Planning Application BR/76/19/PL
33 Shelley Road, Bognor Regis

Proposed Conversion Proposed Plans Planning
Date March 2019
Scale 1:50

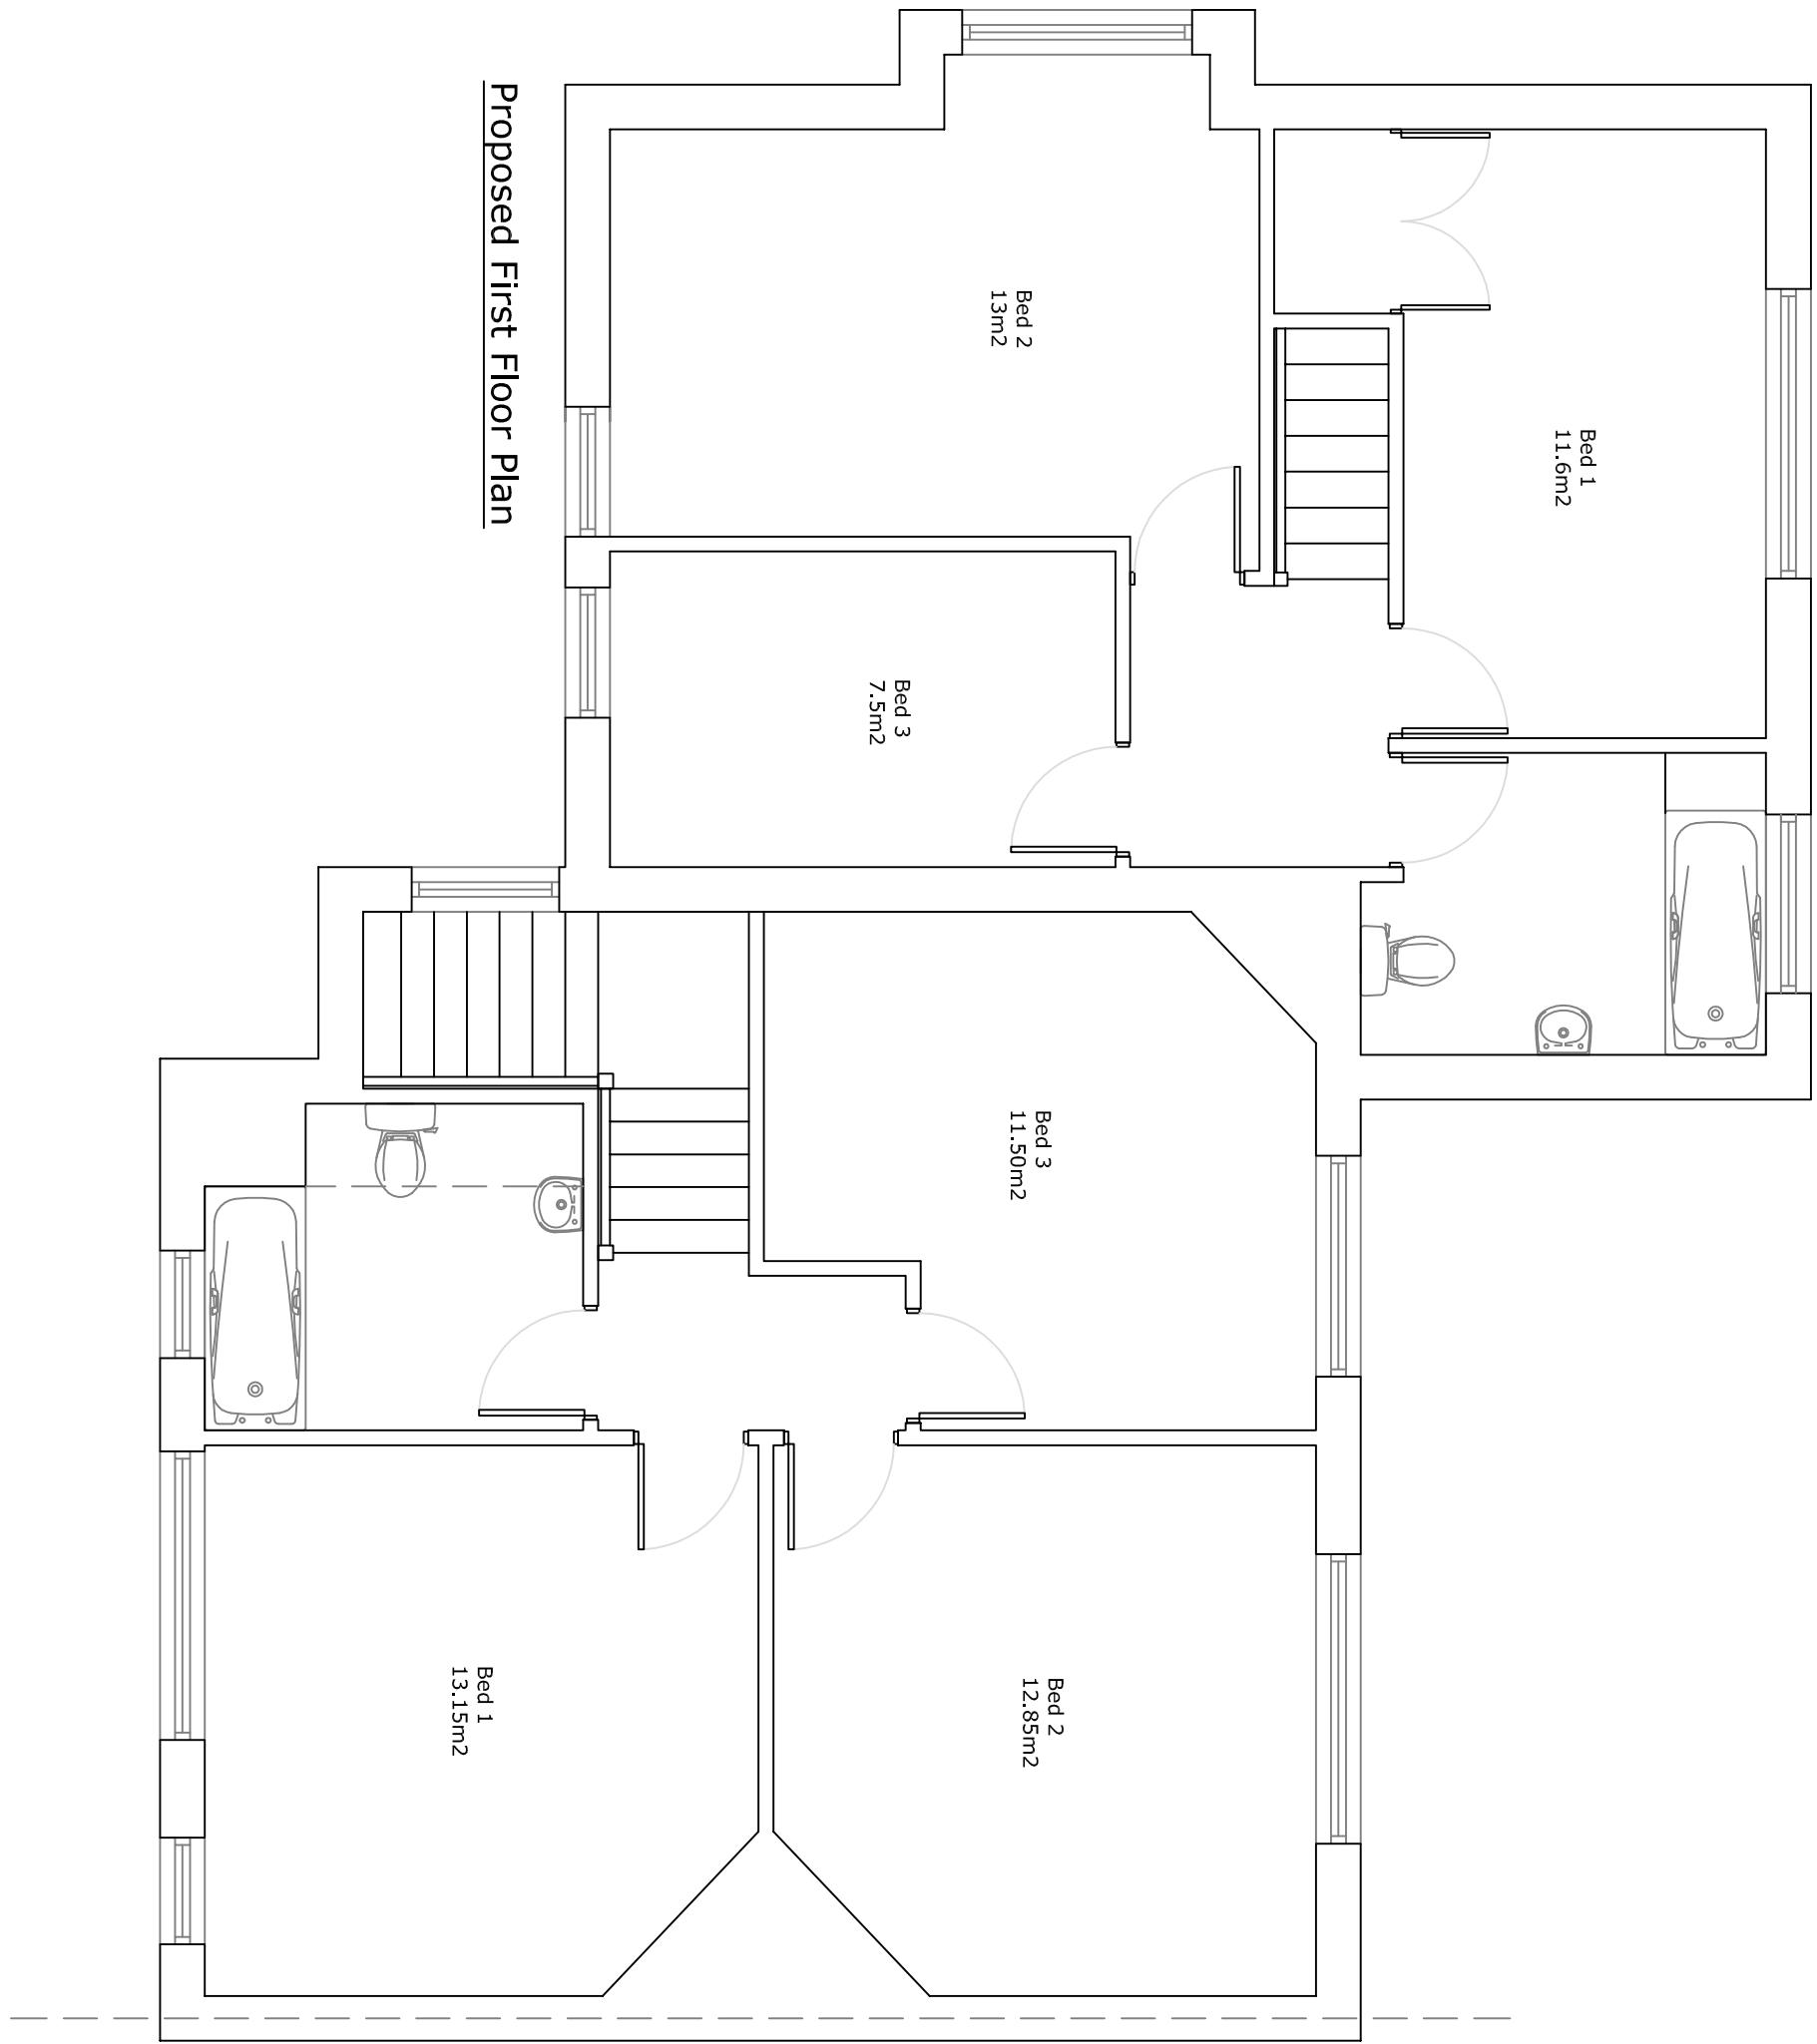
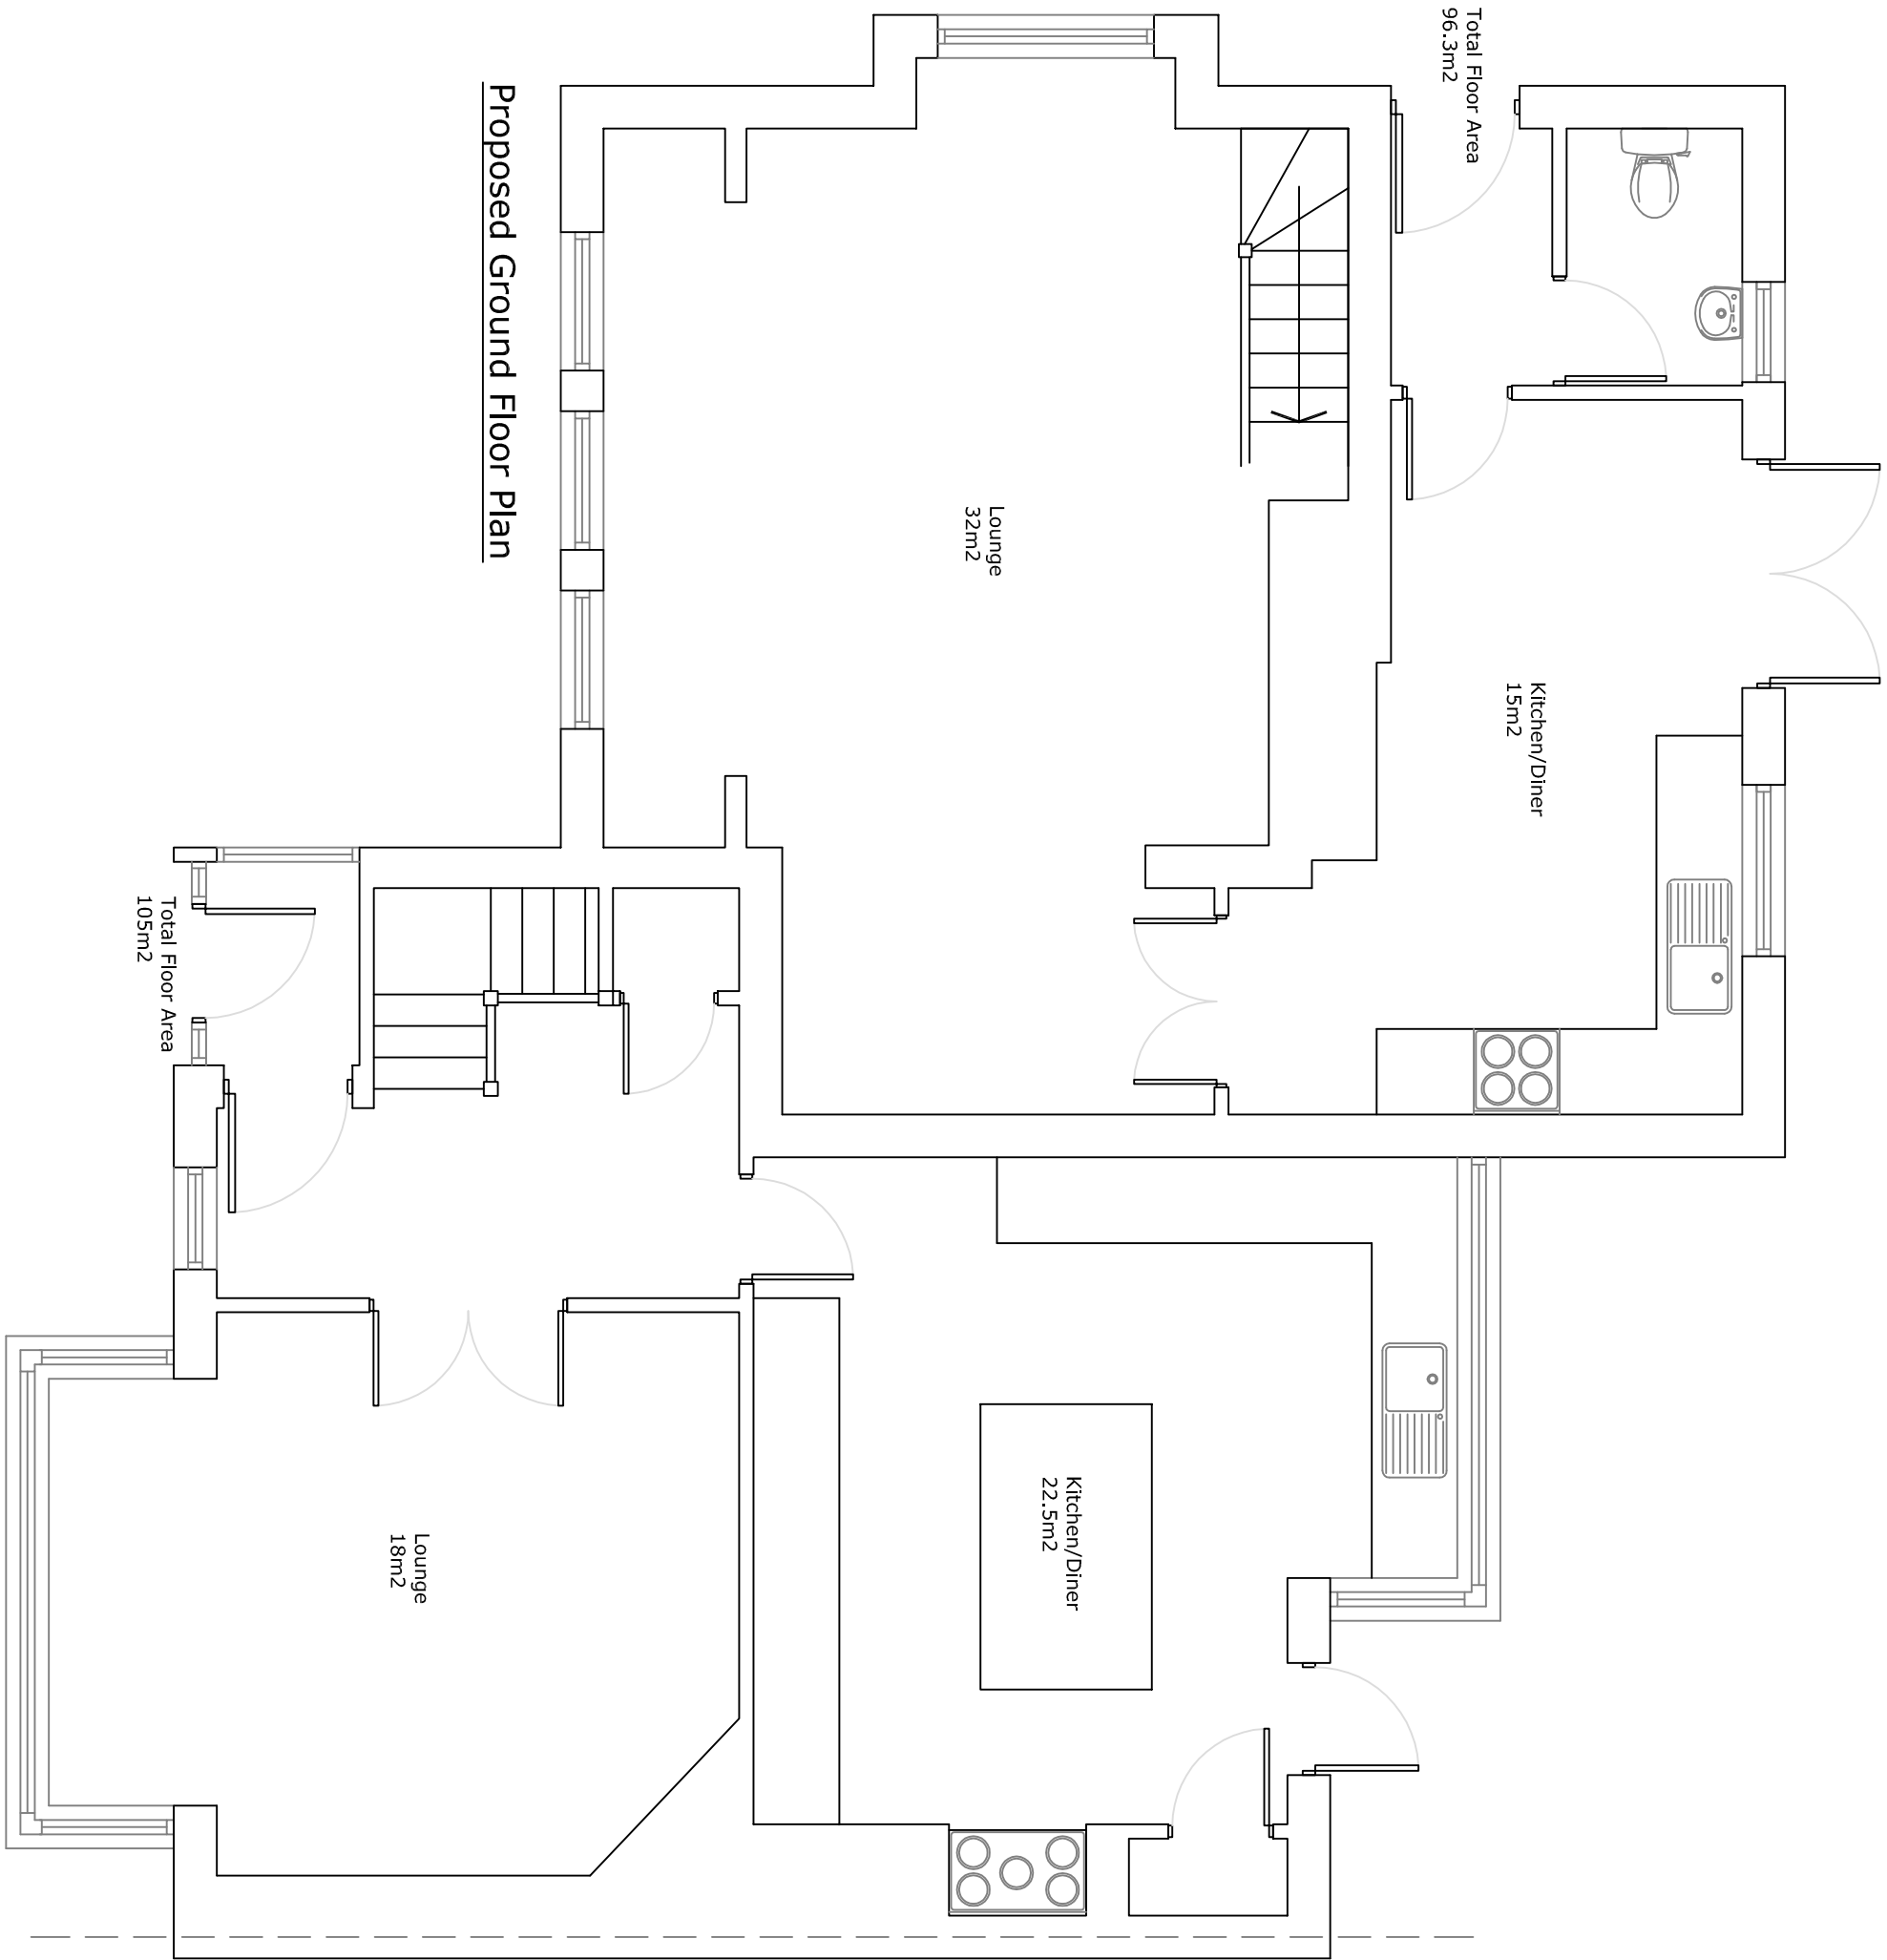
- ① This is an overdevelopment of this site. The property has already been divided once to create the new house i.e. 35 Shelley Road.
- ② The current wooden conservatory at the rear of the property is single storey and glazed on all sides. This allows light to pass onto the kitchen area of the adjacent house i.e. 31 Shelley Road. The proposed two storey extension to replace this would block all light from reaching this part of 31 Shelley Road. Surely this is not permitted under planning law and practice and the occupants of 31 Shelley Road have a right to light.
- ③ Although provision has been made for off-street parking at both the proposed new properties there is still the potential for increased on-road parking near the junction with Elm Grove. This ~~can~~ be a
